North Wales Wind Farm Connection

Response by Robin Barlow to SP Manweb's

“Response to Relevant Representations Document” September 2015

where in section 8.4 they respond to my original Written Representation (numbered 15 by them) to their Application for an Order Granting Development Consent for the North Wales Wind Farms Connection (PINS Ref EN020014)

Figure 14.1 Position of wires (red) and earth wire (green) used for EMF calculations.

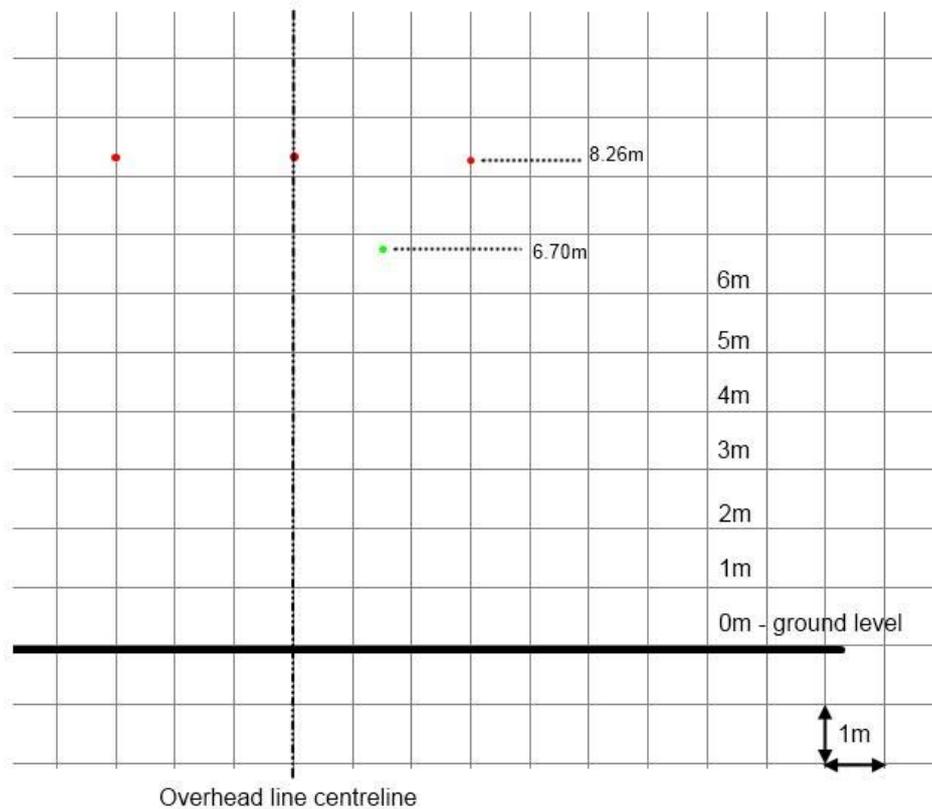
The problem of the earth connector. It certainly does not need to go by the same poles (as Legacy shows) or even be above ground.

Question E1: Counterpoising the earth connector ie laying it underground is a potential solution (as stated by me in my first response). What would it cost ? Possibly <1/6 of the cost of undergrounding the conductors but of course additional to the reduced OHL costs.

Question E2: Can the earth be carried on a Trident solution ? If not why not or where are the limits (mechanical and electrical)? Actually the answer from SP Manweb is YES, it can be carried on Trident. SP Manweb has in several documents shown diagrams of a Trident carrying an earth connector, see for example http://www.spenergynetworks.co.uk/userfiles/file/OHL-03-099_Issue1_ForInternet.pdf (albeit for 33 KV connections, but the weights and tensions must be similar). More recently (August 2015) and more importantly SP Energy Networks has published the the Loch Urr Routeing Consultation Document for a 132KV connection for three wind farms (85,59 and 59 MW capacity) in Scotland. I quote from the section Overhead Line Design starting at R3.3.5 “The 'Trident' wood pole 132KV overhead line design utilises two standard pole types, as illustrated on Figure 3; a 'single' pole and an 'H' pole configuration..... . The spacing between the poles will vary but will generally be 100m The proposed wood pole will support three conductors (wires) in a horizontal flat formation as shown in Figure 3. In addition, there is an earth conductor suspended beneath the main conductors in order to provide lightning protection. This also includes fibre optic cores for communication purposes”. A single sometime double pole Trident with a single bar superstructure, and carrying an earth.
